Re: Application Number: SSD 14_6612
Martins Creek Quarry

We refer to the exhibition of the Environmental Impact Statement (EIS) by Buttai Gravel Pty Limited and thank you for the opportunity to make a submission. Council makes the following comments specific to the EIS as follows:

Drawing Title
**MARTINS CREEK QUARRY
ROAD TRANSPORT ROUTES**

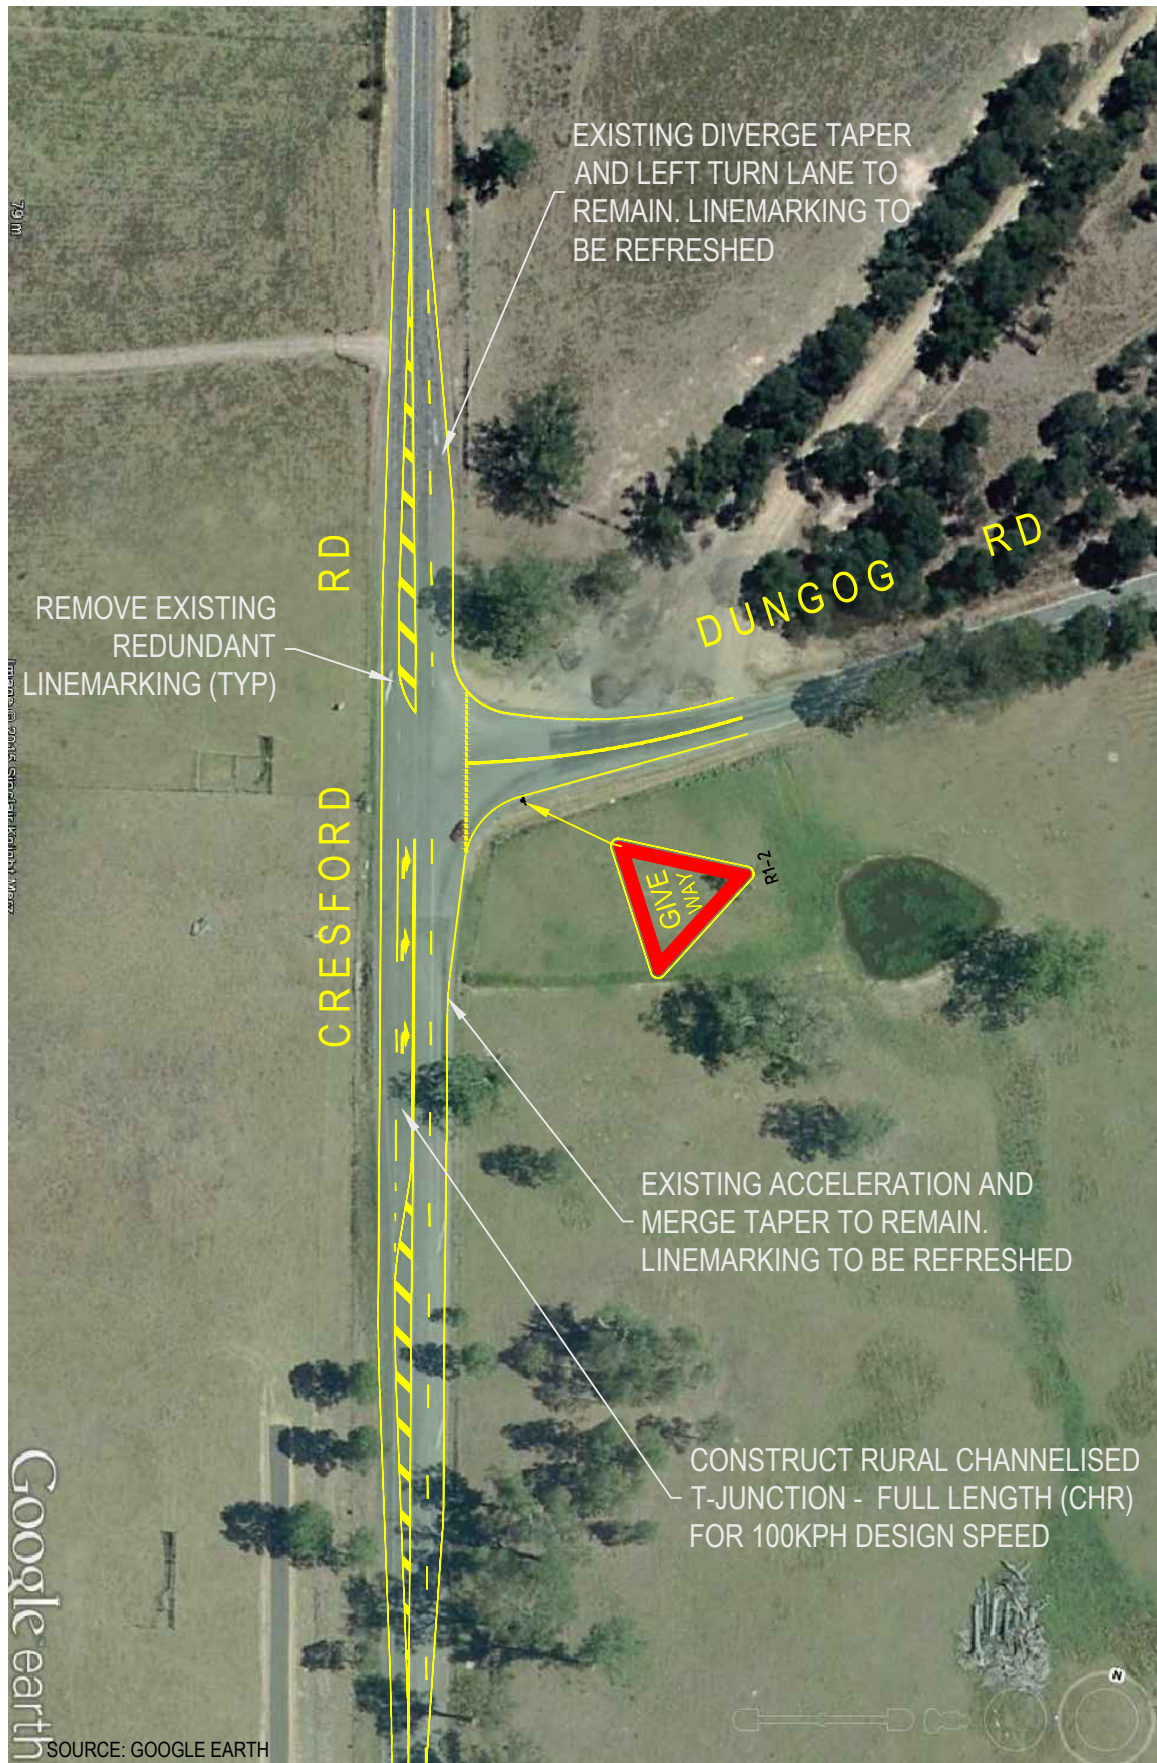
- Further information on truck routes are required to be consistent with the requirements under Schedule 2 of the *Environmental Planning and Assessment Regulations 2000*;

Section 2.10 of the Traffic Assessment by Seca Solutions makes reference as follows "Further information on this project with regard to routes for trucks, split of demand for the end products or details on truck movements generated by this project has not been made available by Brandy Hill Quarry to the study team for Martins Creek" (page 26).

The haulage route proposed in Port Stephens has high environmental values and thus environmental constraints.

Consideration also appears to have not been given to the haulage route through Port Stephens Local Government Area and the effect of State Environmental Planning Policy 44 – Koala Habitat Protection.

The Traffic Impact Assessment (TIA) highlights the potential for virtually 100% of quarry product to be transported on a single route, depending on product sales and demand. This could potentially result in daily truck movements of up to 640 trucks on a single route from Martins Creek Quarry alone. This is unacceptable to the local community and would result in severely accelerated damage to Council's road network. While it is acknowledged that this scenario is unlikely to occur in practice, the potential for high volume traffic movements in this area should be considered in any approval process.

Information provided in the EIS suggests Martins Creek Quarry will have 215 one way truck movements per day with 25.1% of those truck movements traversing through the proposed haulage route through Port Stephens. This equates to approximately 42 one way truck movements or 84 two way truck movements per day. Council considers that truck movements from Martins Creek Quarry together with the expected increase for Brandy Hill Quarry is excessive for residents particularly within the Brandy Hill community.

Council requests that the Department consider limiting of the use of compression braking for haulage trucks in residential and rural residential areas, particularly along Paterson Road, Butterwick Road and Brandy Hill Drive.

MARTINS CREEK QUARRY
BUTTERWICK & CLARENCE TOWN ROAD INTERSECTION WORKS

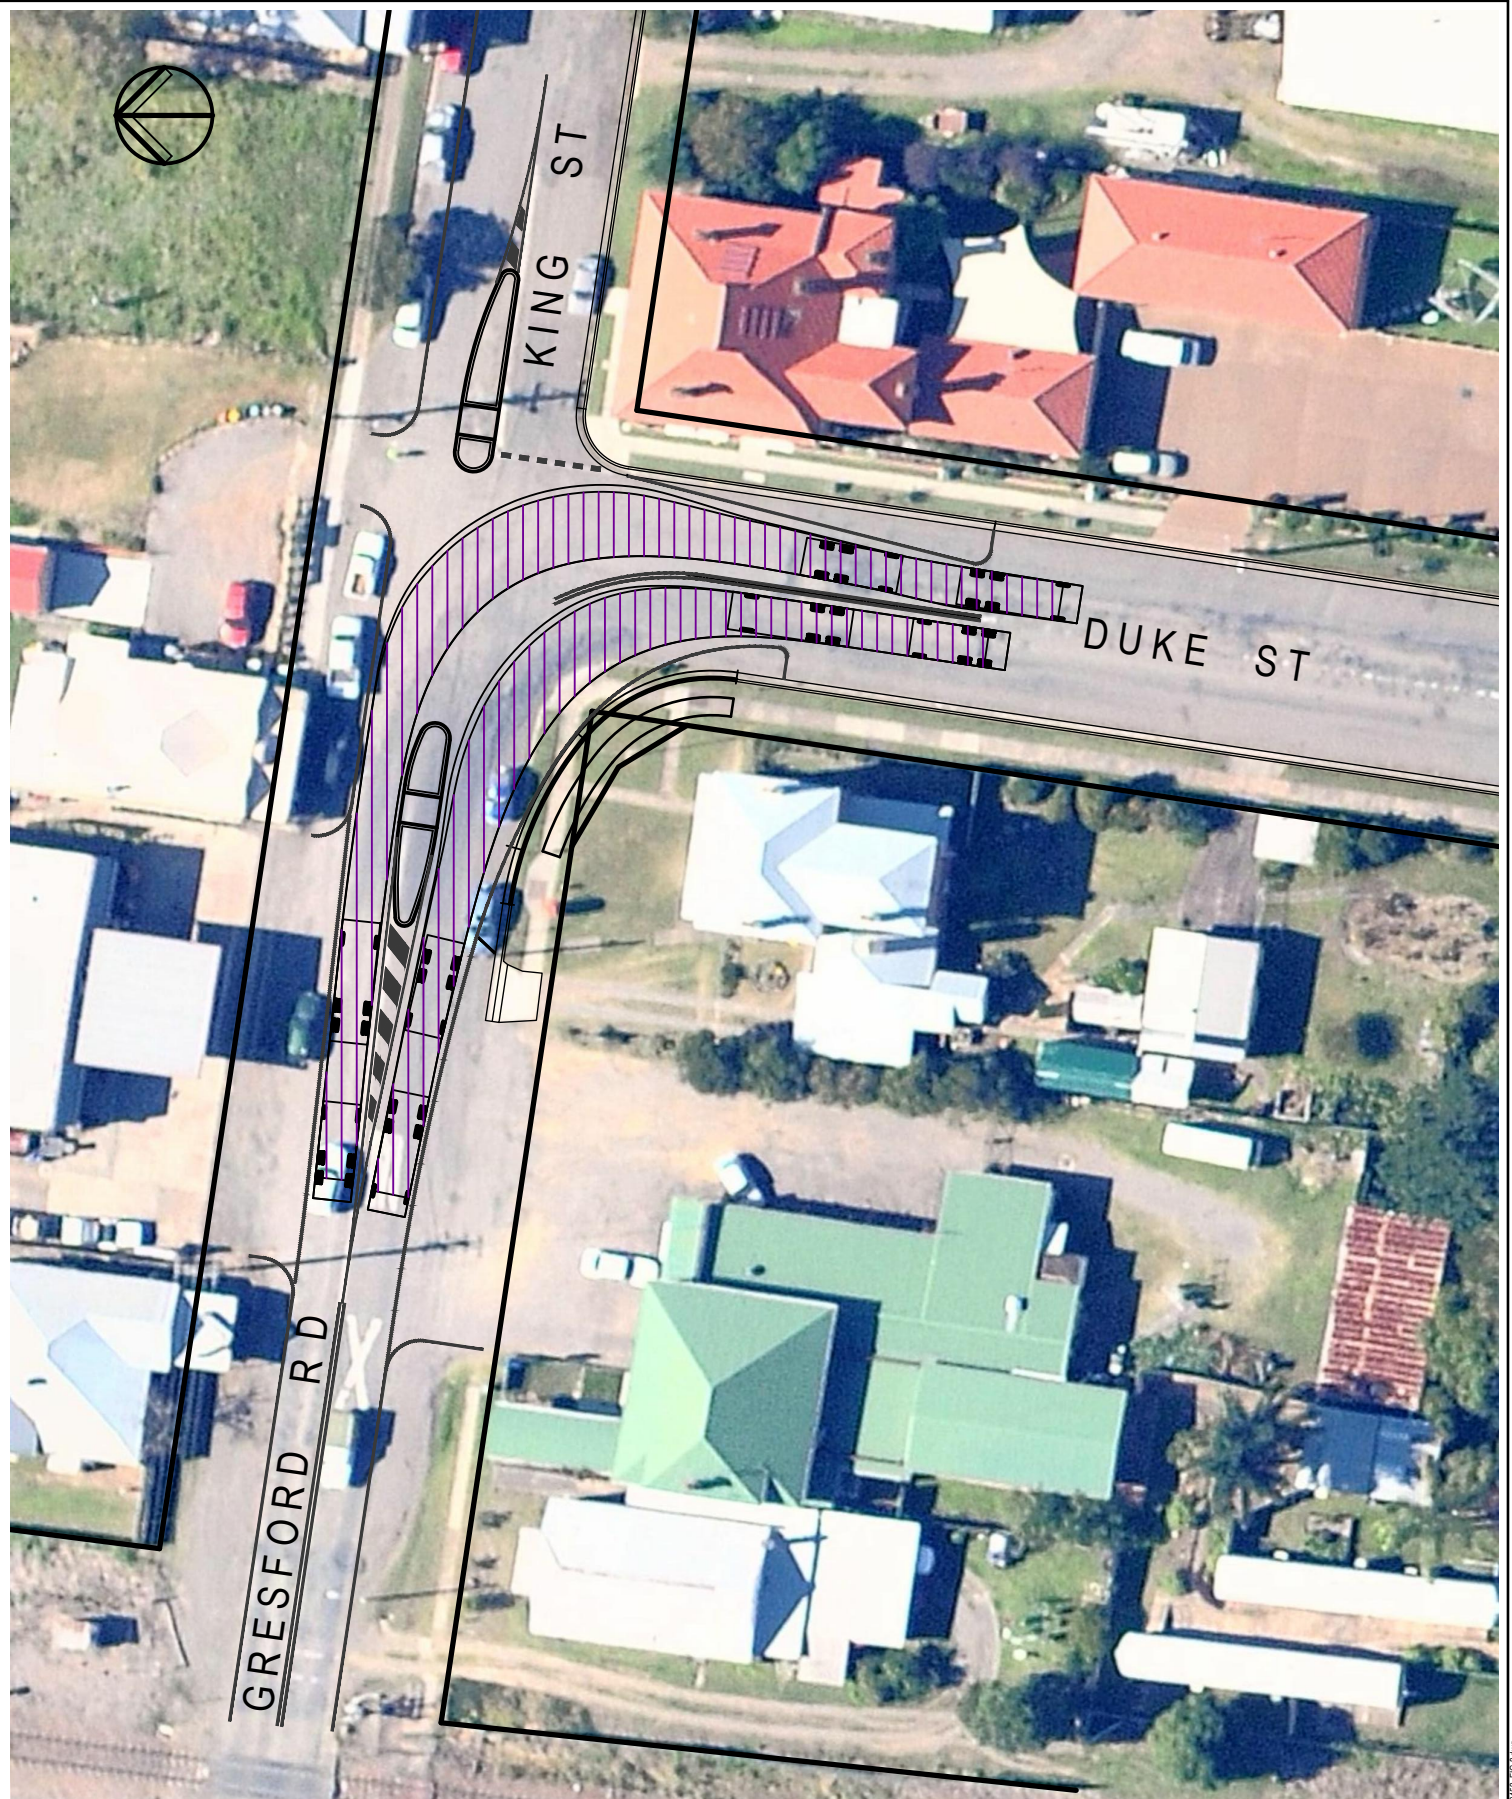
Council does however support the upgrade of the intersection at Butterwick Road and Clarence Town Road intersection.

MARTINS CREEK QUARRY
BRANDY HILL DRIVE AND CLARENCE TOWN ROAD
INTERSECTION WORKS

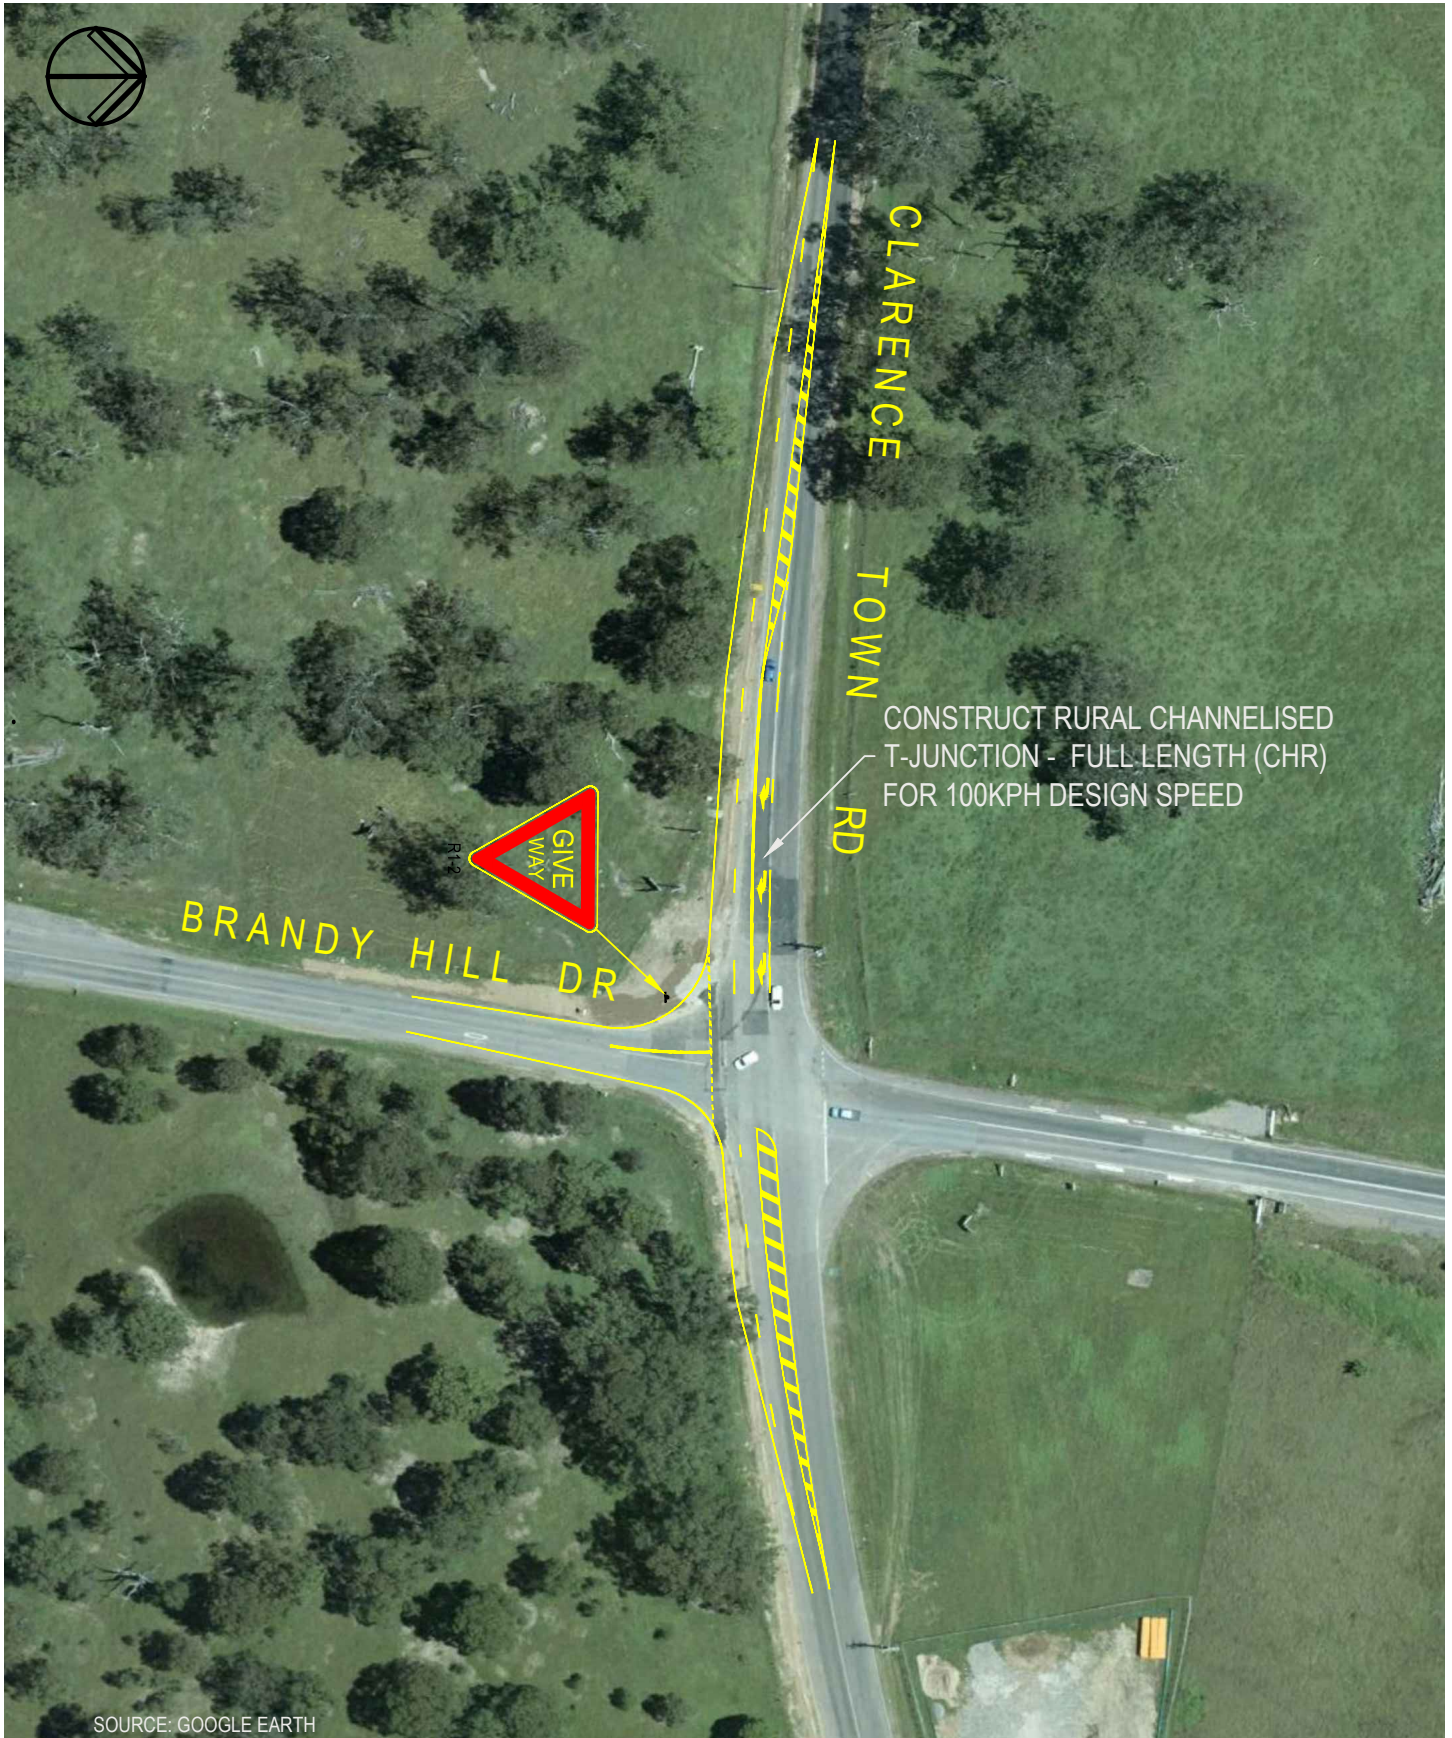
The intersection of Brandy Hill Drive and Clarence Town Road is also a safety concern with the lack of a right-turn bay posing a safety risk to road users. The report links an upgrade of this intersection to the proposed expansion of the Brandy Hill Quarry.

Council is of the opinion that the right hand turn will only affect Martins Creek Quarry and not Brandy Hill Quarry, as the Brandy Hill Quarry trucks do not turn right from Clarence Town Road on to Brandy Hill Drive. Council will require this intersection to be upgraded to allow a right turn.
